25 May 2018

Elmsbrook Bicester - Phases 3 & 4 | Non-Technical Summary

This non-technical summary aims to respond to the queries raised by the planning officer on 13th March 2018 with regards to Planning Condition 10 (risk of summer overheating), following the submission of the overheating report produced in December 2017.

Figure 6 - Dwelling 227

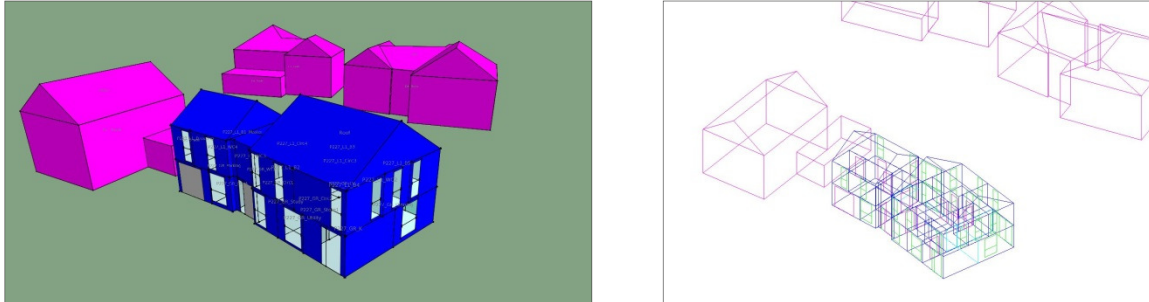
1. I would question whether residents would be content to leave ground floor windows open during night time hours and I think it is not appropriate to rely on this?

2. My understanding is that on previous phases it was specified that windows would not be open on the ground floor during the night?

3. Would the opening of windows on upper floors be sufficient to achieve the cooling required?

As outlined in the overheating report produced in December 2017 the only house type requiring ground floor windows to be opened at night was the 5B10P type (plots 30, 195, 226 and 227). This would have been on a controlled aperture restrictor and for certain time periods only, however, we understand the concerns residents may have with leaving ground floor windows open so have further looked into ways to avoid this requirement.

All four of these plots have been designed with a Ventive passive ventilation system which wasn't taken into account when the overheating report was initially produced in December 2017. Data for this system has now been included in a recent review of the overheating analysis with the aim of removing the requirement to open ground floor windows at night.

To summarise this review it was found that the Ventive passive ventilation system combined with the strategy of opening bedroom windows during night time hours and installing blinds to the high risk bedrooms (beds 2, 4 and 5) removed any overheating risk in the current and 2030 scenarios. For the 2050 scenario an additional measure of installing blinds to all habitable rooms, including the downstairs rooms, would need to be implemented. These four plots, as with all other plots on this site, have been designed so that blinds can be fitted if or when needed.

It is correct that on the previous phases the overheating strategy did not require ground floor windows to be open during night time hours. On phases 3 & 4 there was only one house type (5B10P - plots 30, 195, 226 and 227), where the December 2017 overheating report suggested opening ground floor windows during night time hours but, as confirmed in the response to question 1 above, this has now been overcome with a combination of the Ventive passive ventilation system, opening bedroom windows during night time hours and installing blinds to beds 2, 4 and 5 (current and 2030 scenarios) or installing blinds to all habitable rooms (2050 scenario).

With the inclusion of data from the Ventive passive ventilation system the risk of overheating in all three scenarios for the 5B10P type has now been reduced. In addition to the Ventive system the current and 2030 scenarios will require upstairs windows to be open at night and blinds installed to the high risk bedrooms (beds 2, 4 and 5). The 2050 scenario will, in addition to the above, also require blinds adding to all other habitable rooms.

The only plots that require blinds are plots 30, 195, 226 and 227 (5B10P type). To meet the requirements of the current and 2030 scenarios blinds will need to be installed to bedrooms 2, 4 and 5. These will be installed prior to the properties being sold. To meet the requirements of the 2050 scenario additional blinds would need to be installed to all other habitable rooms in this plot type but this would be done by the occupier at that time.

Residents will not be expected to adapt their homes to reduce any overheating risk within 20 years of first occupation. The only time that residents would have to adapt their properties is in the 2050 scenario where additional blinds will be required to all habitable rooms in the 5B10P plot type, however, out of the 228 plots on phases 3 and 4 only four plots fall into this category.
